# PLANNING AMENDMENT

| <b>SITE ADDRESS DETAILS</b><br>28 WESTLODE STREET, SPALDING, PE11 2AF.                                         |  |                                                                                                                           |  |
| <b>CURRENT APPLICATION NO:</b><br>This amendment cannot be considered unless the relevant reference is stated. |  | H16 - 0208 - 26                                                                                                           |  |

| <b>FULL DESCRIPTION OF DEVELOPMENT OF CURRENT APPLICATION THAT THIS AMENDMENT RELATES TO</b>                                                                                             |  | CHANGE OF USE FROM CAFE TO |   |

PROPOSED REAR ELEVATION. 1:50.

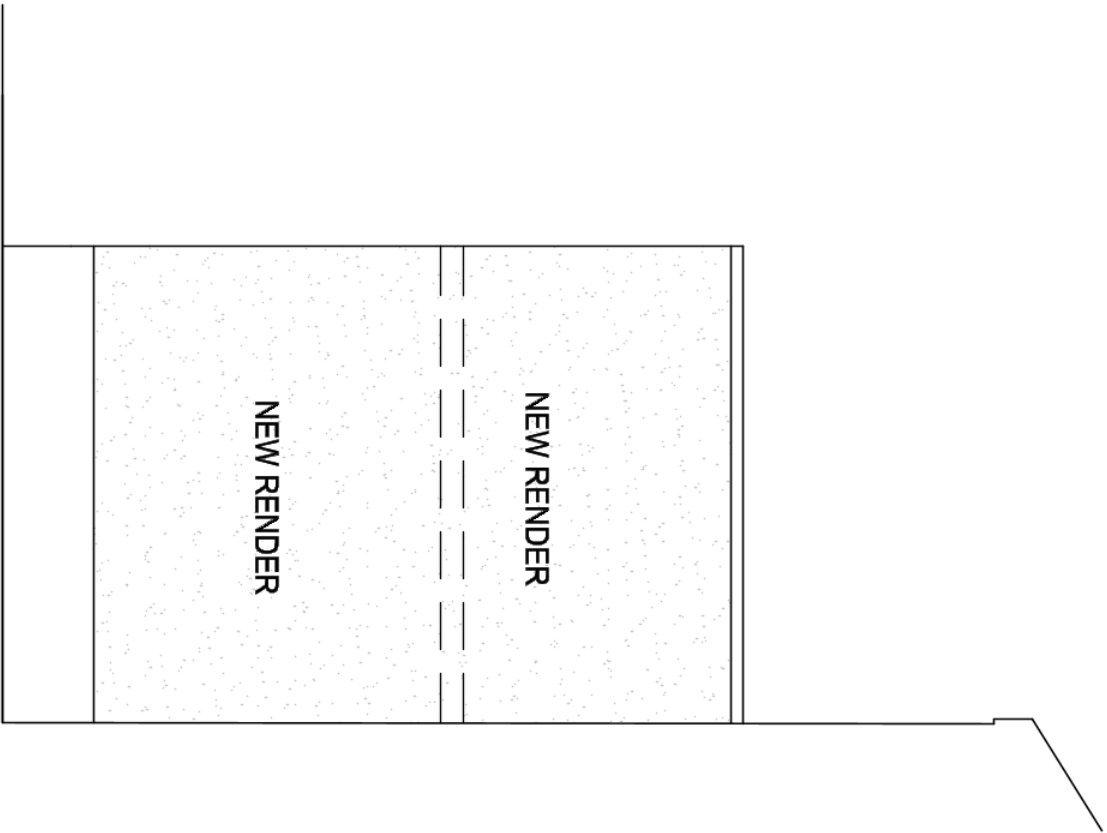
| State details of amendments proposed. (Give a full detailed list of the changes, and also mark these clearly on the accompanying plans. Only the changes listed here will be considered) |  | CHANGES CARRIED OUT AS     |   |
| Describe any part of the original development which is excluded by virtue of the amendment, and state any alteration to plot numbers                                                     |  | FRONT ELEVATION FLAT DOOR  |   |
